From: Michael Eastham
Sent: 14 September 2017 15:41
To: Planning.Responses
Subject: FW: AL/83/17/PL – Mildmay - Hook Lane Demolition of existing dwelling & erection of 1 No. dwelling

Planning application AL/83/17/PL – Mildmay - Hook Lane Demolition of existing dwelling & erection of 1 No. dwelling

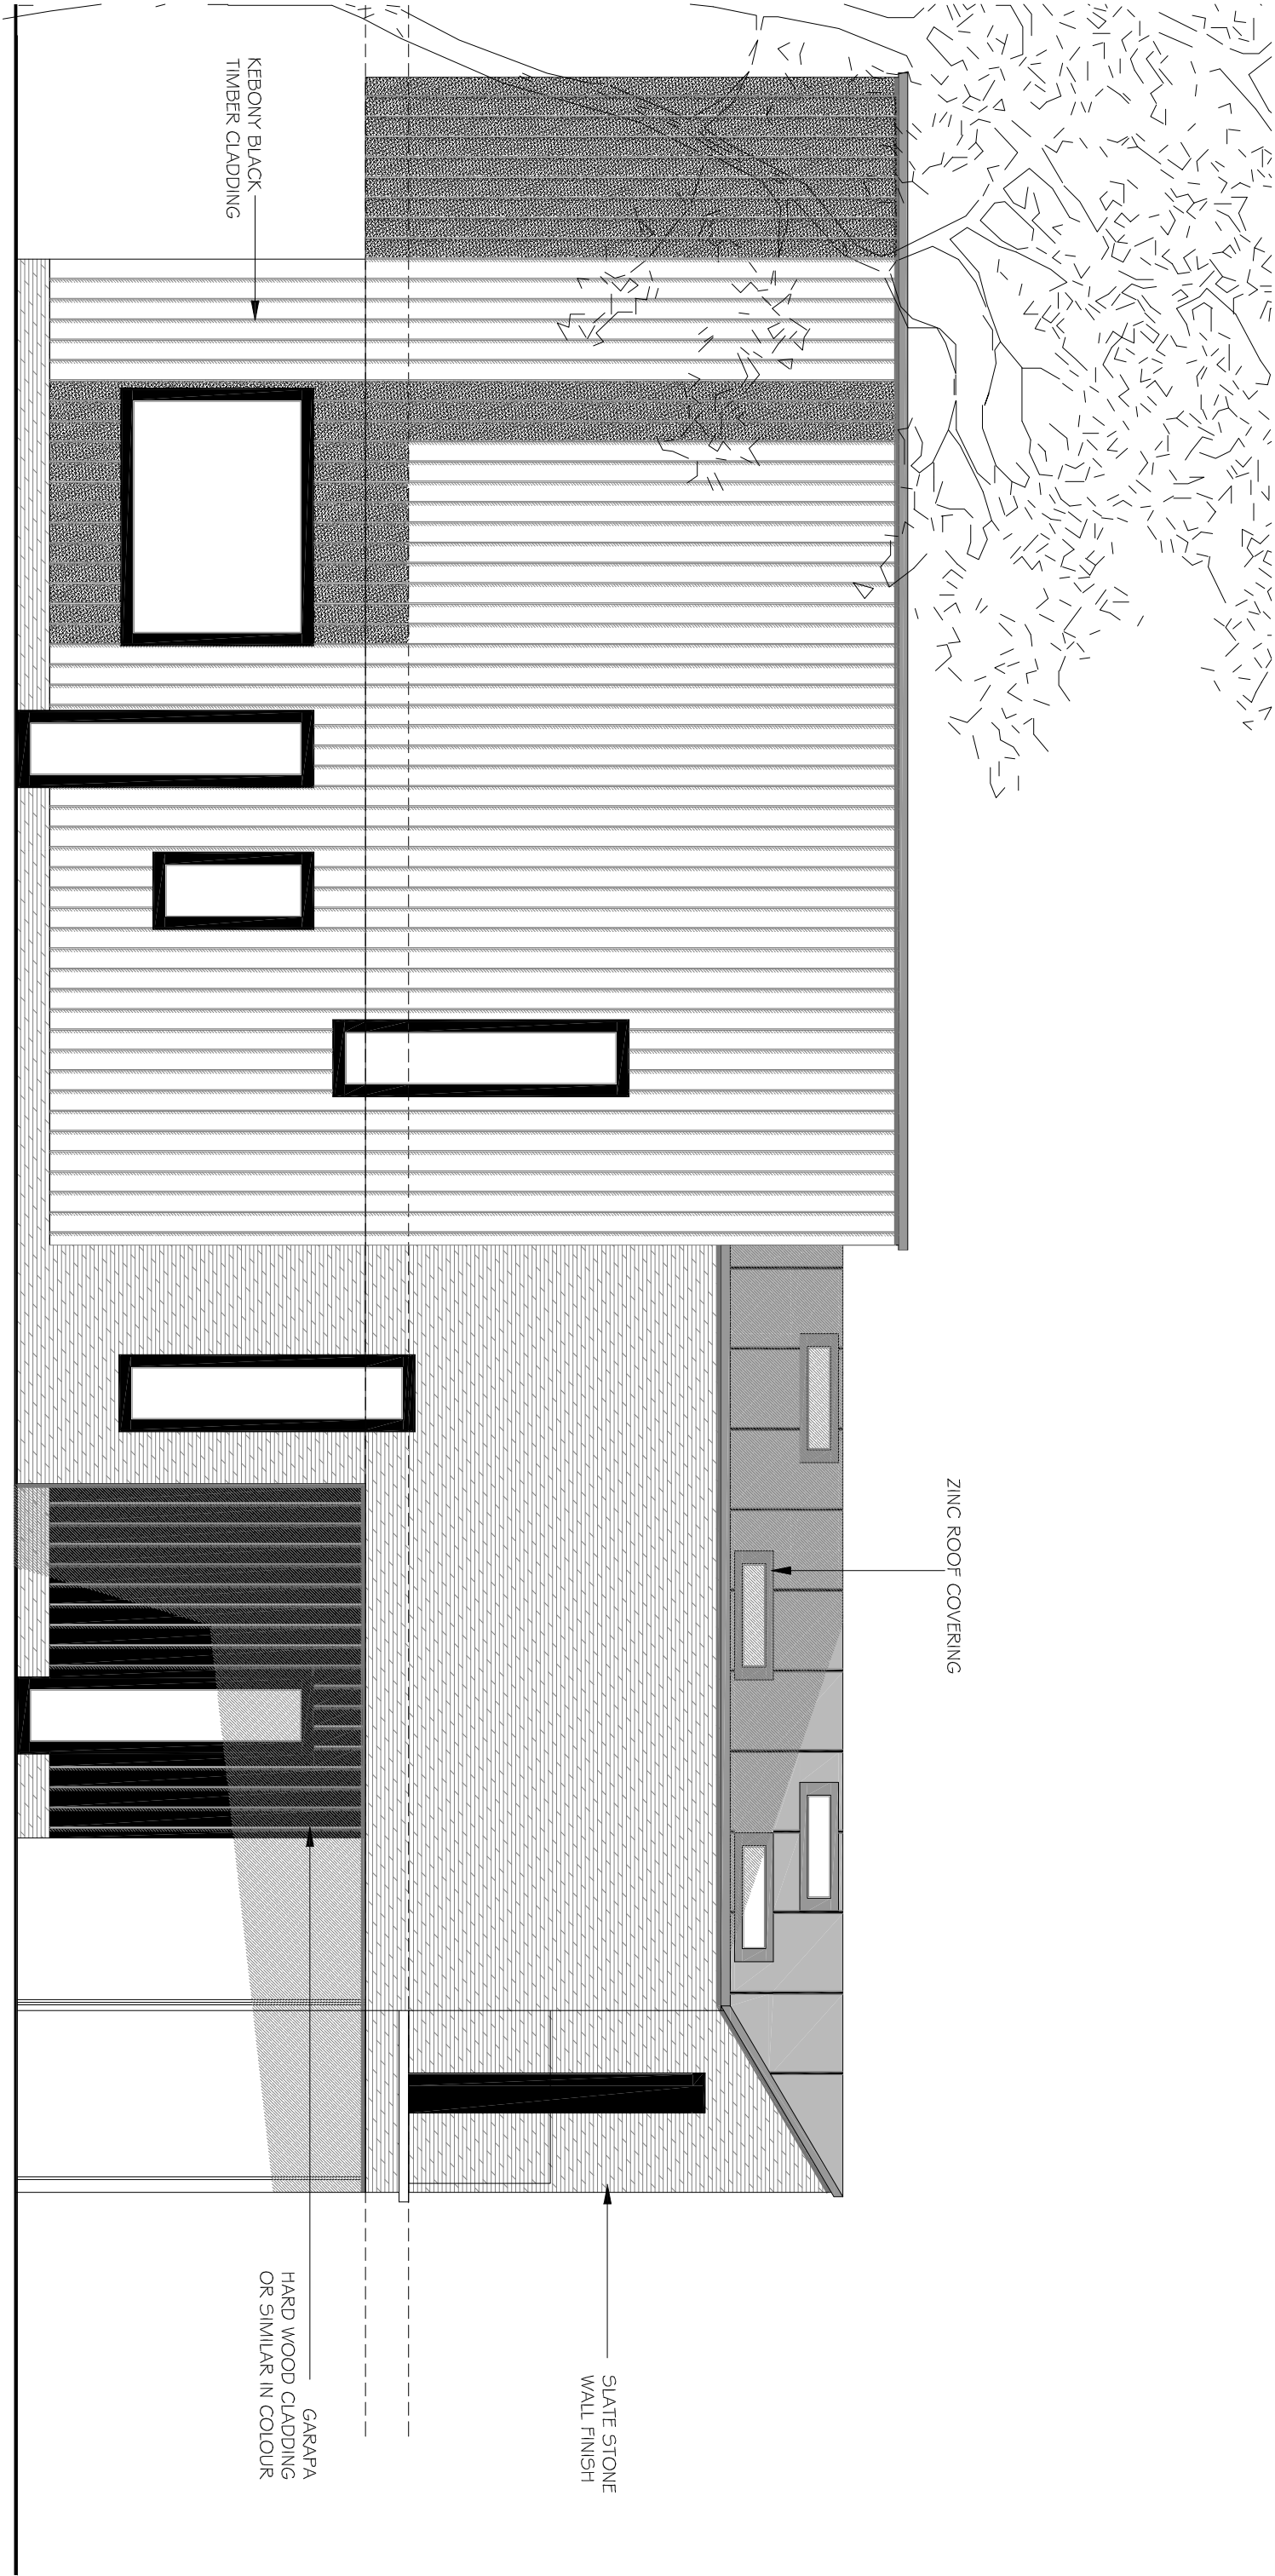
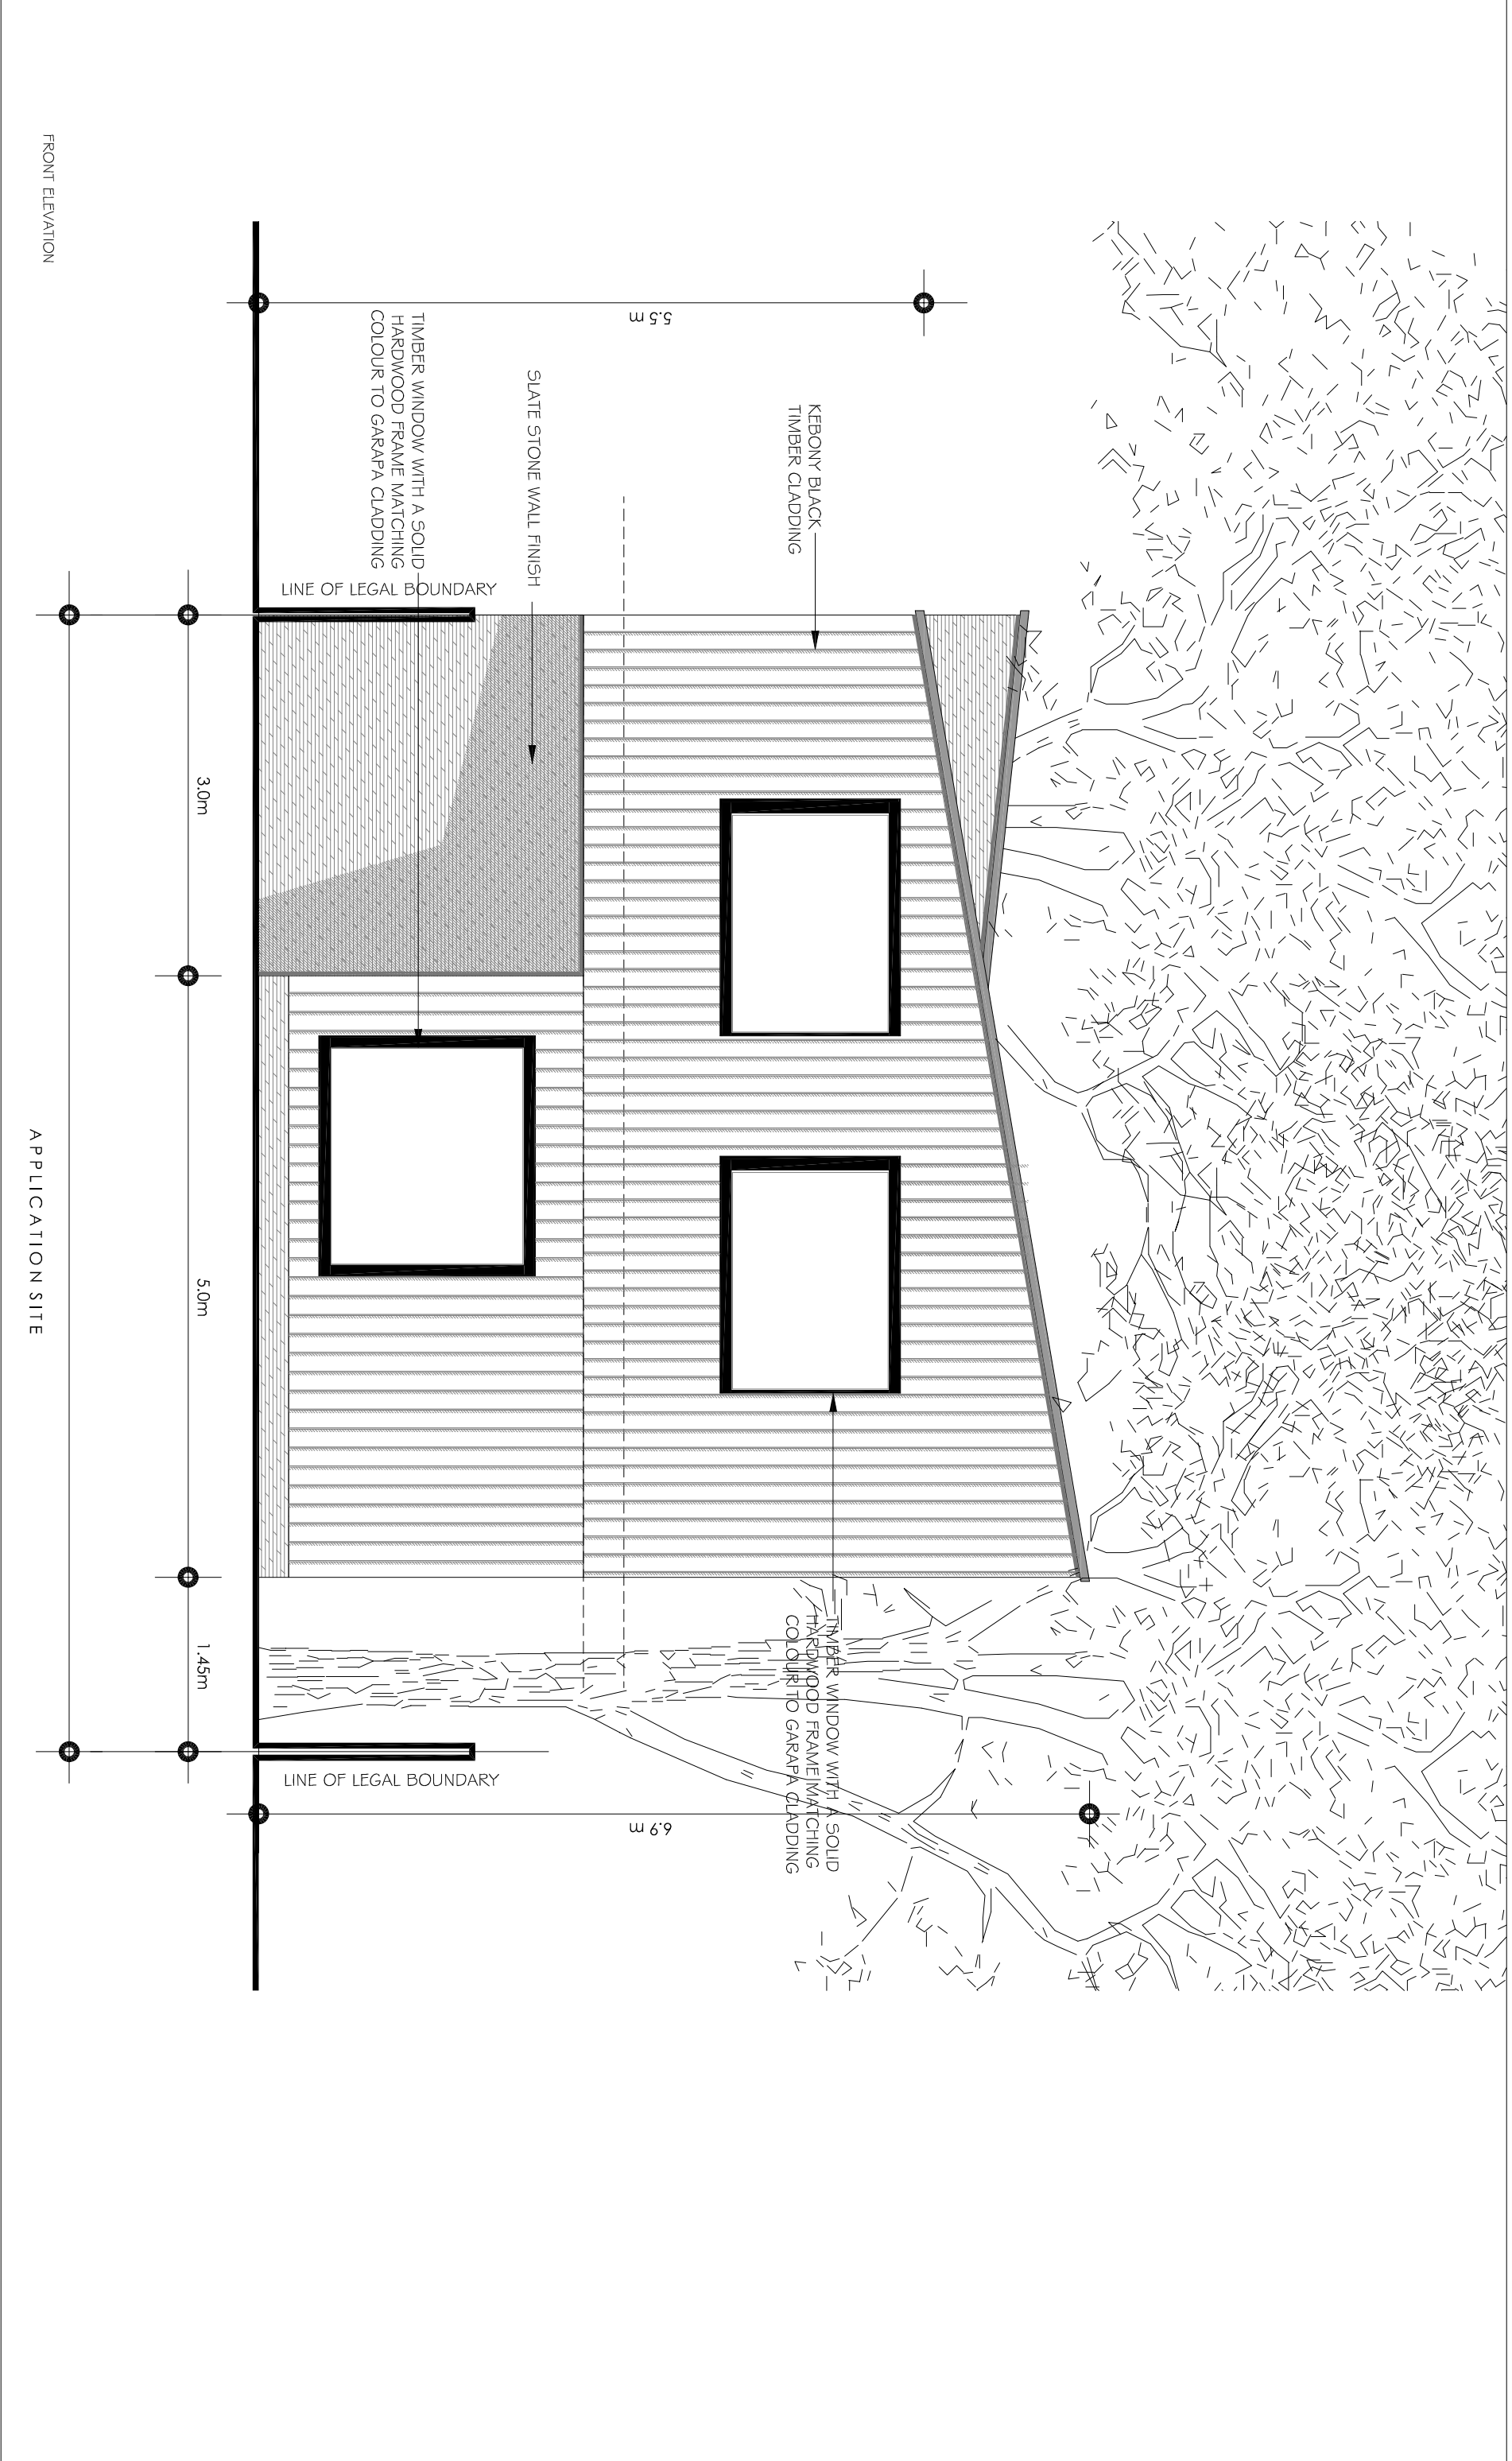
The principle of constructing a replacement dwelling on the site of the unfinished wooden bungalow is acceptable. However, the size, scale, and appearance of the proposed replacement dwelling is completely out of keeping with the character and appearance of the existing houses along Hook Lane and the streetscene.

The proposed dwelling would fit perfectly in a shoreline setting or a woodland setting within Arun District, but it is completely out of keeping with the character of the properties on Hook Lane.

I would be happy to work with you on identifying an alternative house type for the plot of land at Mildmay, but I could not support the current proposed development on the plot.

Looking at the adjacent properties and the stand-off distances, a replacement bungalow would be the ideal solution. The bungalow – or a single storey pavilion style structure - could have a very modern appearance and would probably work really well on the site.
